**A122 LOWER THAMES CROSSING (REF: TR010032)  
DEADLINE 6 SUBMISSION**

**LINFORD LAND GROUP - AFFECTED PARTY REFERENCE: AP1631**

**MULBERRY STRATEGIC LAND LIMITED – AFFECTED PARTY REFERENCE: AP1581**

## Linford Borehole & Water Pipeline

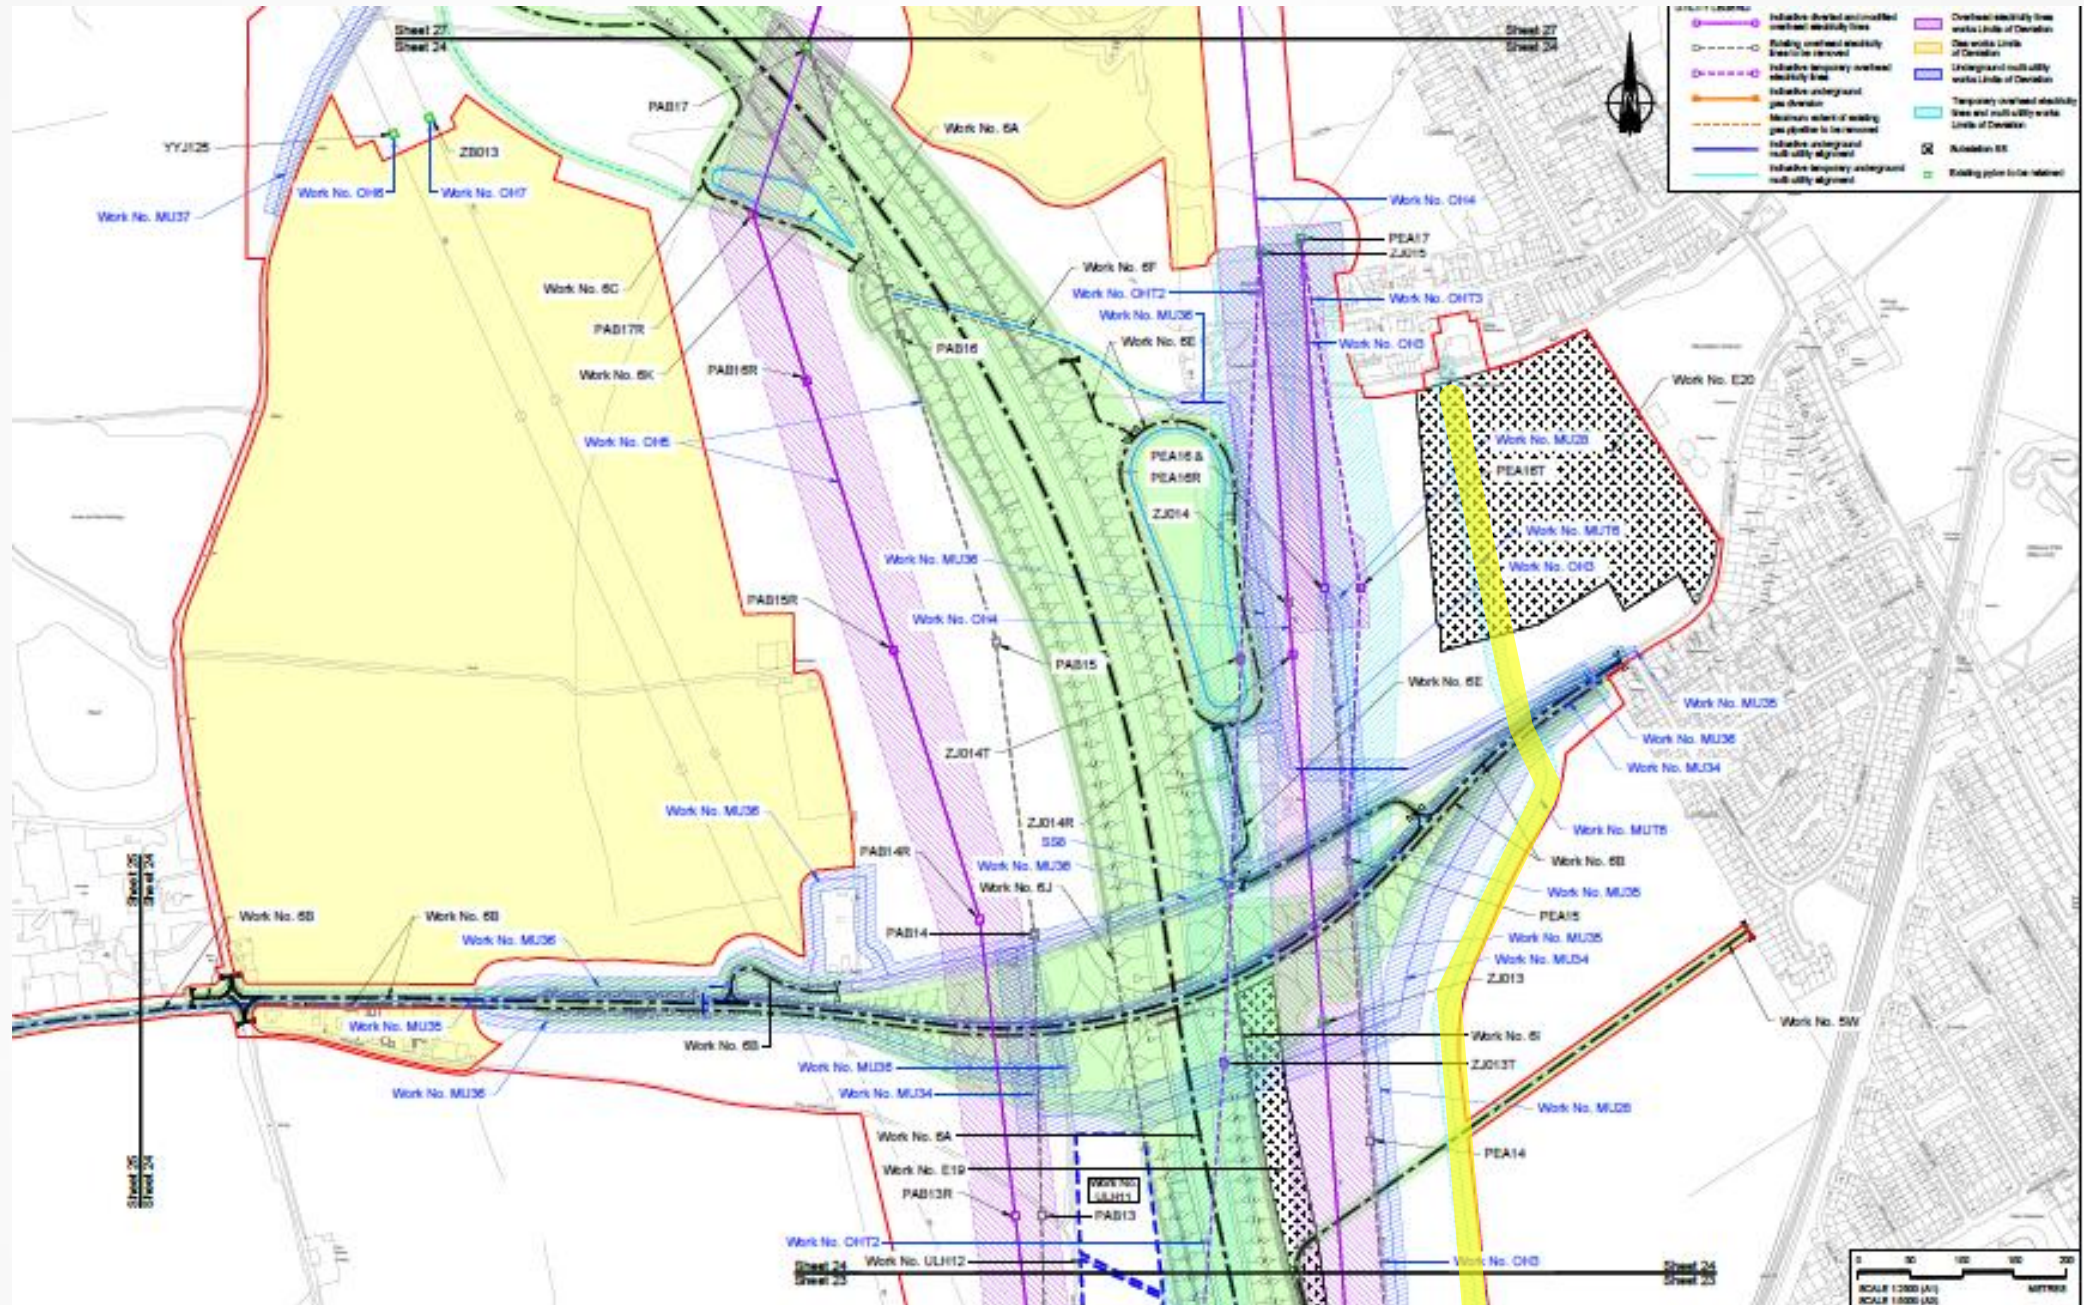
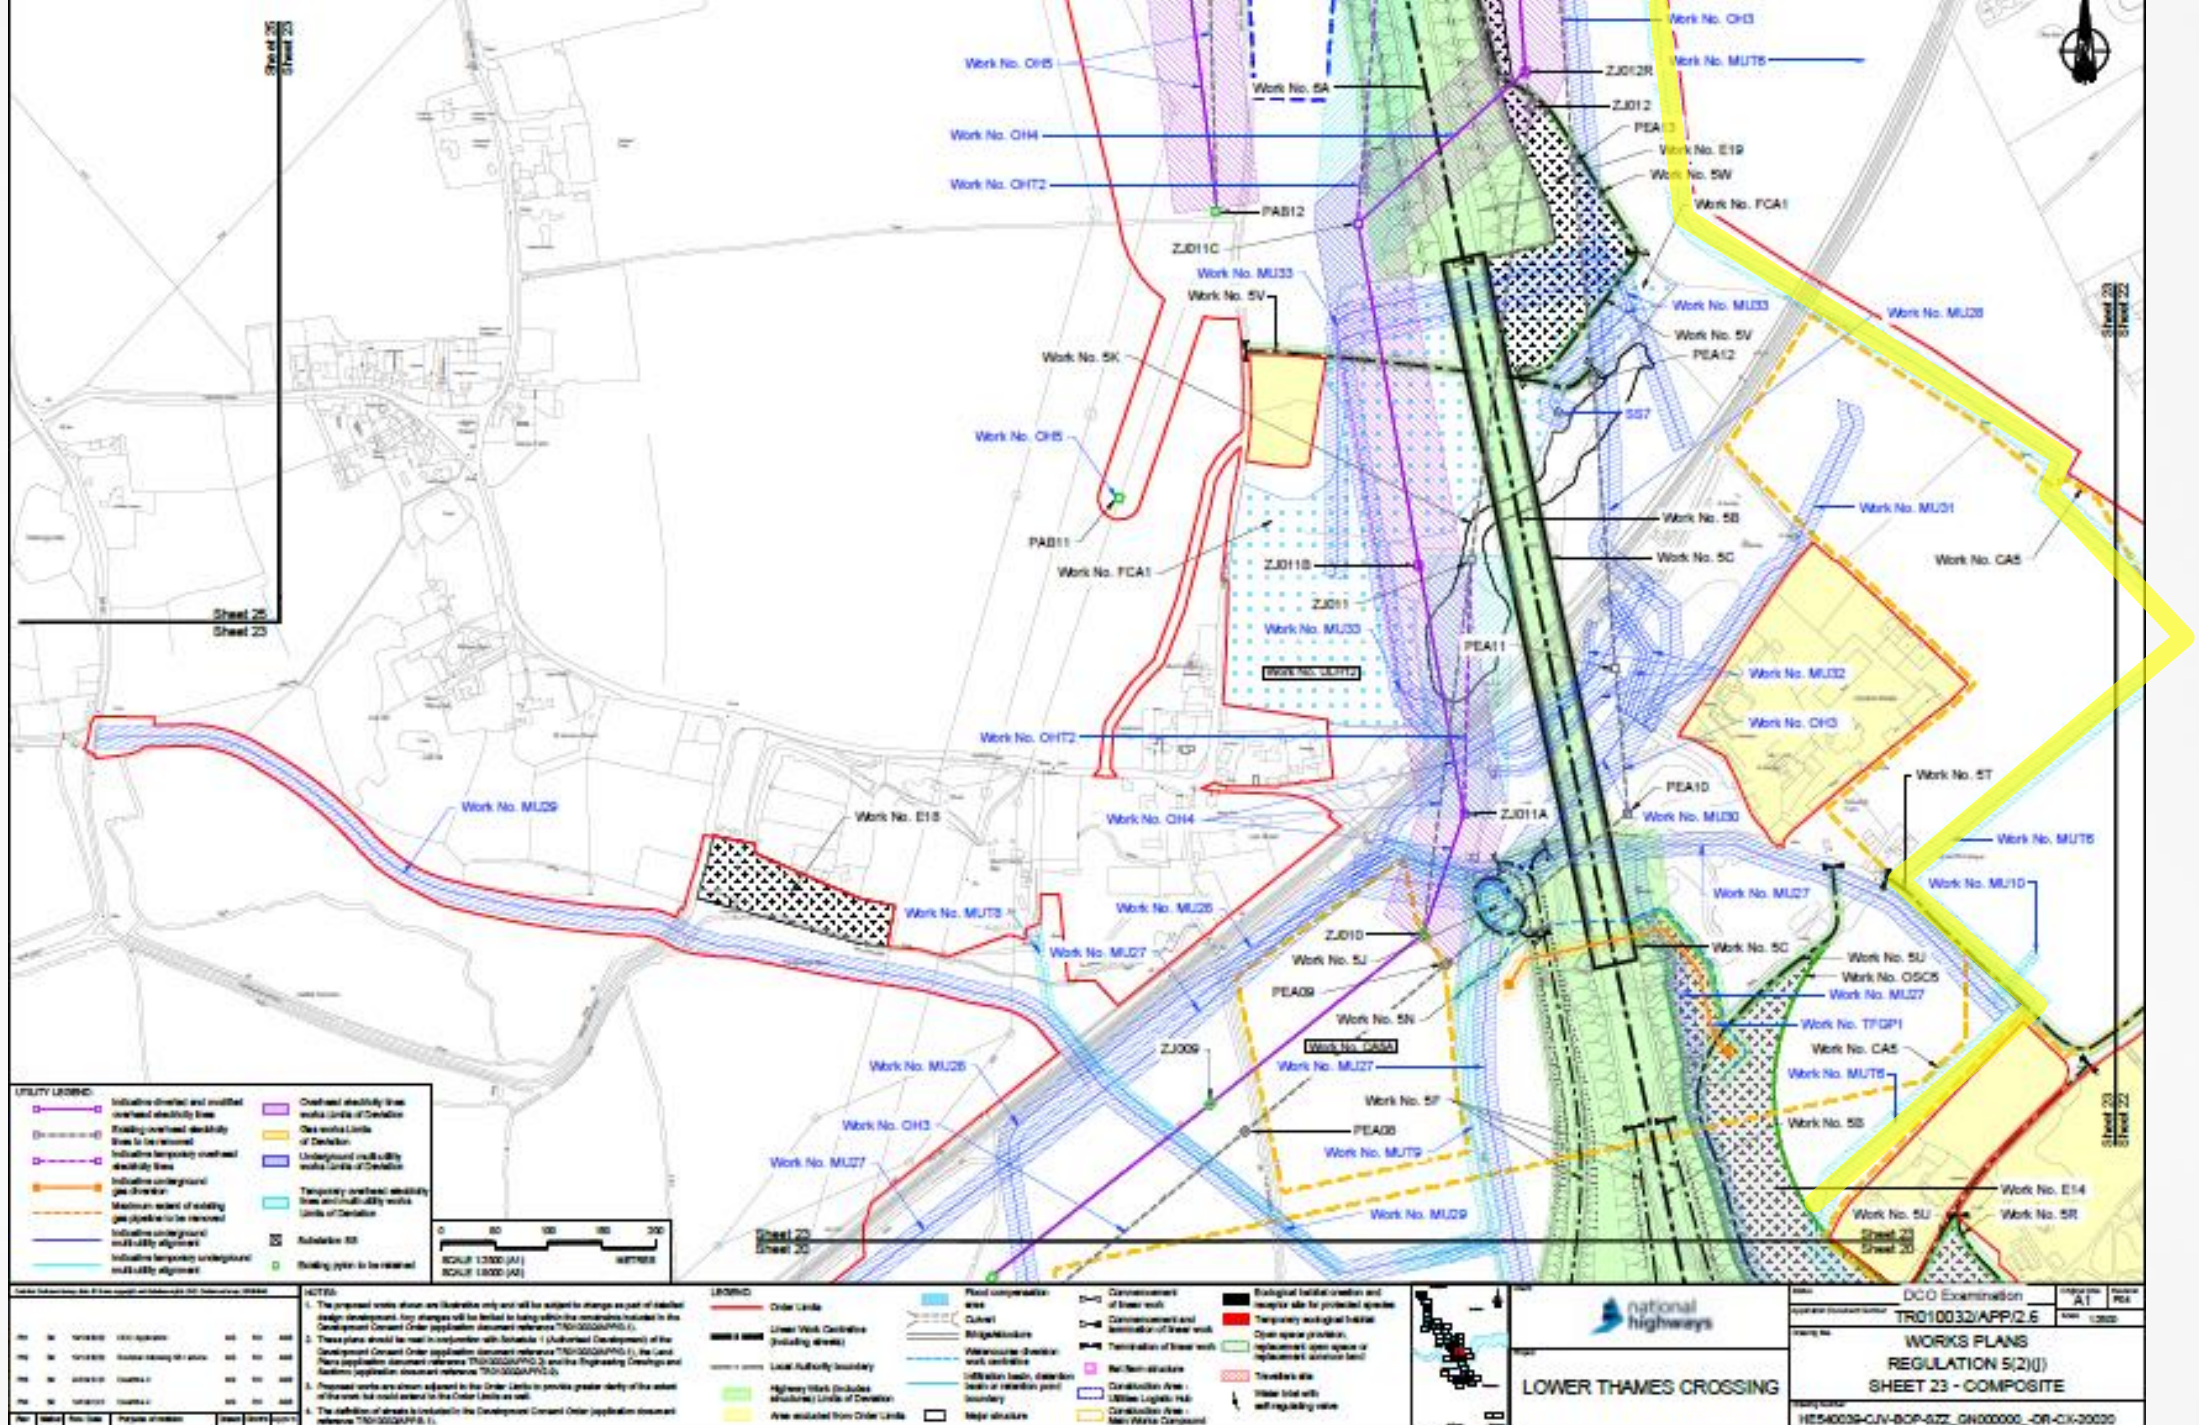
<p><b>Linford Borehole &amp; Water Pipeline</b></p>	<p><b>Plates 79 &amp; 80</b> - show the proposed temporary water pipeline route highlighted on the Applicant's Works Plans Volume C Composite v.5.0 REP5-020</p> <p>Referring to <b>Plates 70 and 71</b>, the area of temporary possession and temporary possession with permanent rights proposed by the Applicant for this purpose and other utilities works is as shown on the Applicant's Land Use plans REP5-800 and is principally comprised of Plots 23-72, 23-175, 23-177, 23-180, 24-124, 24-191, 24-192 and 24-193 on Sheets 23 and 24.</p> <p><b>ISSUE:</b></p> <p><b>Permanent Rights for Temporary Pipeline</b></p> <p>We refer you to the Deadline 2- Applicants Response to IP comments on draft DCO at Deadline 1 REP2-077 which stated:</p> <p><i>5.7.3 The Applicant has, in limited circumstances, sought rights and restrictive covenants to enable statutory undertakers to have adequate land and rights in connection with temporary assets. The Applicant is aware there are concerns from affected landowners regarding those rights sought for temporary utility works that would enable the construction of the Project (Work Nos OHT1–OHT8 and MUT1–MUT32) and is considering its options and available mechanisms from which to provide comfort to landowners that these rights will be extinguished at the earliest opportunity unless otherwise agreed with the landowner.</i></p> <p><i>5.7.4 In relation to the proposed Linford water pipeline (Work No. MUT6) plot numbers 23-121, 23-139, 23-153 are listed in Schedule 8 of the draft DCO [REP1-042] which sets out the requirements for land within the Order Limits. Permanent rights are required for the installation and operation of the temporary water pipeline, which would be removed following construction</i></p> <p><b>Plate 81</b> – shows the water pipeline route in relation to our client's planning application landscape framework and location of SUDS layout.</p> <p>The area to the west of the spine road, through which the Applicant's temporary water pipeline is proposed (in the Applicant's plot numbered areas as set out above) is multi-functional and proposed to be made up of the following:</p> <p>It is the main body of open space on site (over 50% of all spaces) and the largest single area within our client's development by some measure.</p>

- i) Technically the northern part of the site cannot be drained through conventional means without using land which the Applicant requires for utility works and the temporary water pipeline.
- ii) The absence of this land at the outset of our client's development will render the balance of our client's open spaces insufficient to fulfil SANG objectives.
- iii) This land forms a key social and amenity function for new residents and is the main area of open space for recreation (whilst also fulfilling key technical functions) under our client's development proposals.

2) In our opinion, there continues to be no justification for permanent rights for a temporary water pipeline and our client objects to any permanent rights which result in the statutory undertaker seeking continued use beyond use by the Applicant for the purposes of the Project.

<p>3) With reference to the Applicant's stated position (as set out above) in respect of removal of the pipe, a technical working group with the Applicant, their design and build contractors, our client should be formed to agree the best approach to decommissioning the pipeline together with a SACR commitment that the pipeline will be removed on cessation of use or a removal commitment should the pipeline prevent any future development of the land area in which the pipeline is constructed and with the full cost of that removal and all associated remedial works being met in full by the Applicant's or relevant statutory undertakers.</p>
--	--

1) form a technical working group of our client, statutory undertakers and the Applicant's appointed design and build contractors to agree a methodology and timetable for works to enable our client's Phase 1 and 2 development requirements to be satisfied during the Applicant's construction phase and to ensure that suitable mitigation is in place to address any adverse effects of the Project on our client's development scheme – during and post construction.
